Environmental Health Consultation Response

To	Aishwarya Reddy
Date	05-04-2025
Planning Ref	BE/46/25/A
Site Description	Unit 1 Saltbox Road Bersted Bognor Regis West Sussex PO22 9FP
Date of Application	2025-04-01 00:00:00
Category	Application
Recommendation	No Objection No Objection – with conditions Objection Holding Objection

Subject: Planning Response BE-46-25-A - Unit 1, Saltbox Road, Bersted, Bognor Regis, West Sussex, PO22 9FP

Advertisement Application
Proposed LED Signage
SLTBX - BSL-AD- XX - DR - A - 4005 - G1
Saltbox Road, Bognor Regis
West Sussex, PO22 9FP
Richmond Motor Group
18020
1:50, 1:1000 @ A3
PLANNING

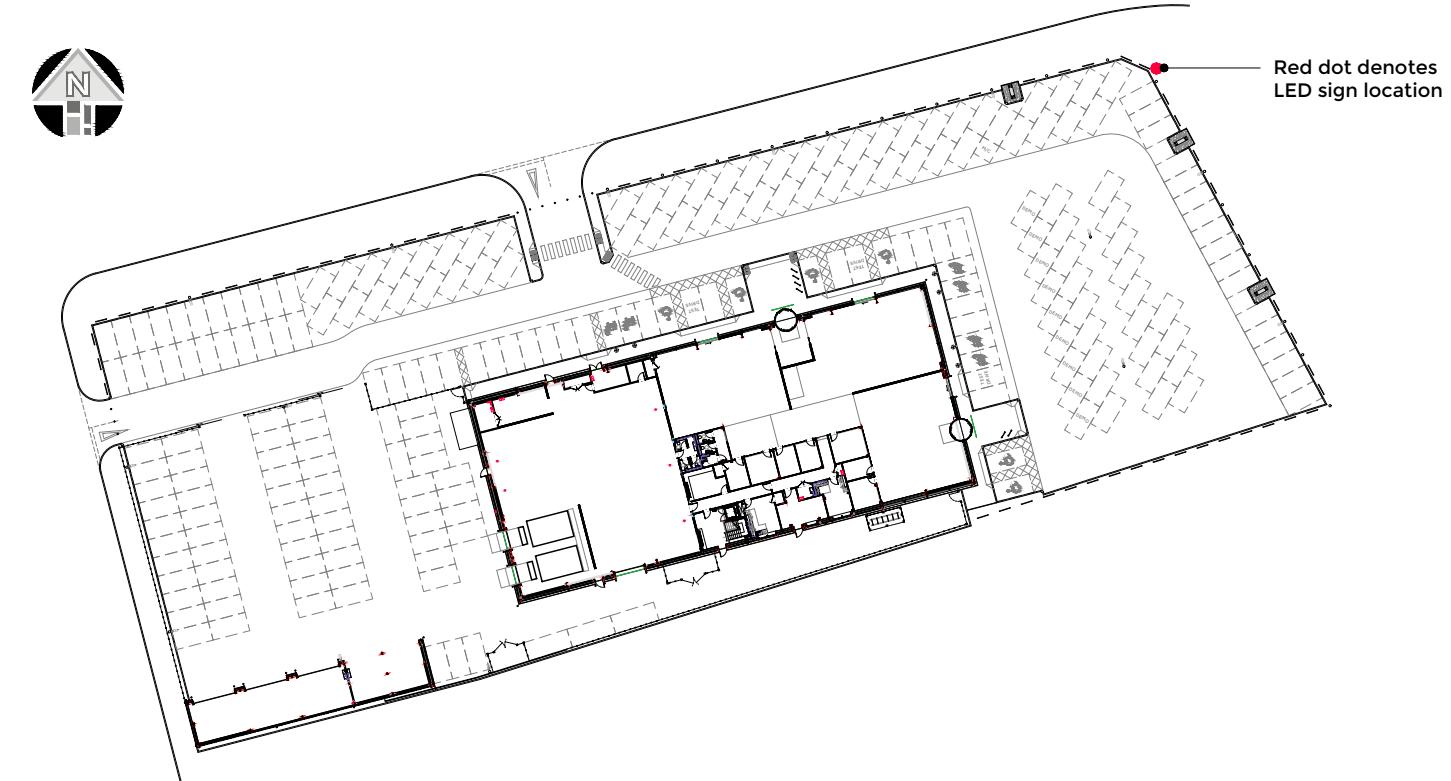
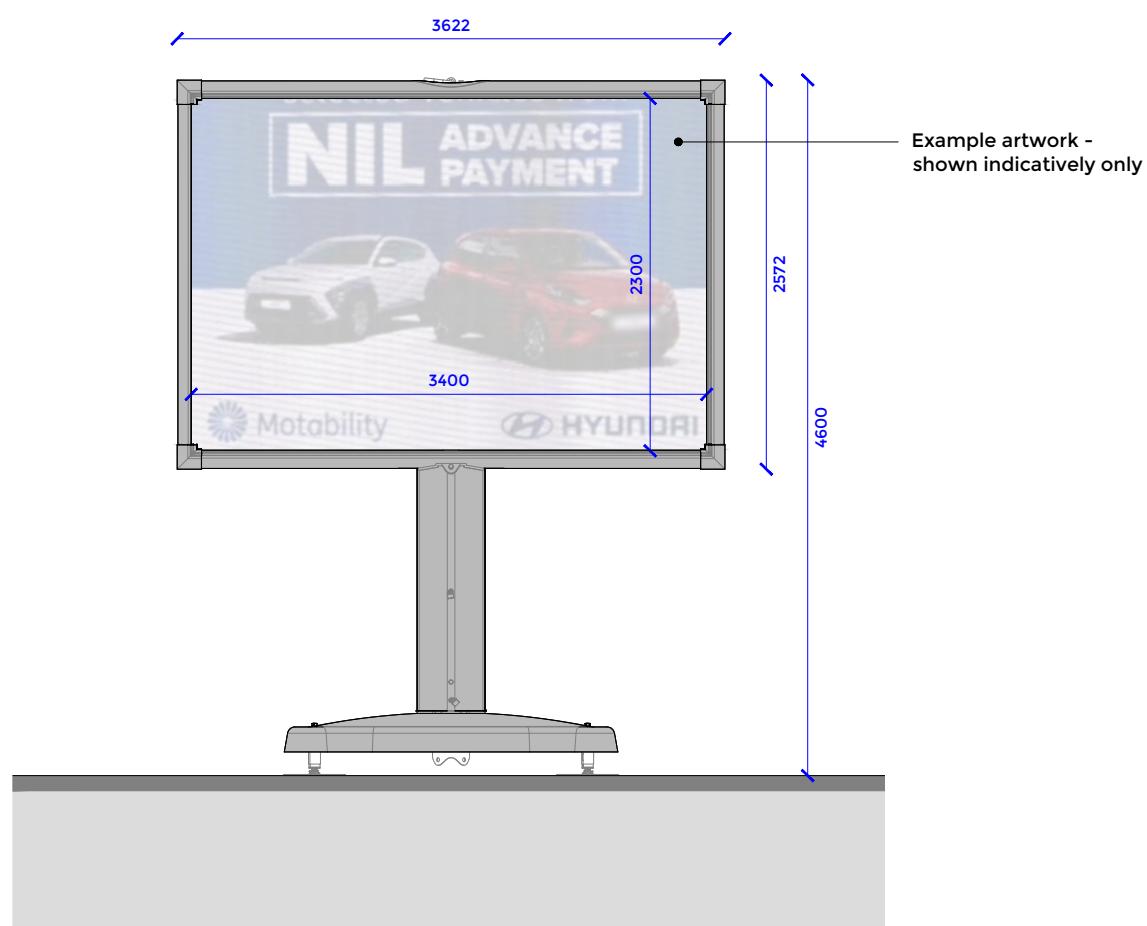
I have reviewed the above application and while I have no objections in principle the information provided is not satisfactory to be able to assess the impact from the illuminated sign.

In order to alleviate our concerns, we need to see evidence that the proposed sign complies with the Institution of Lighting Professionals guidance PLG05 The Brightness of Illuminated Advertisement.
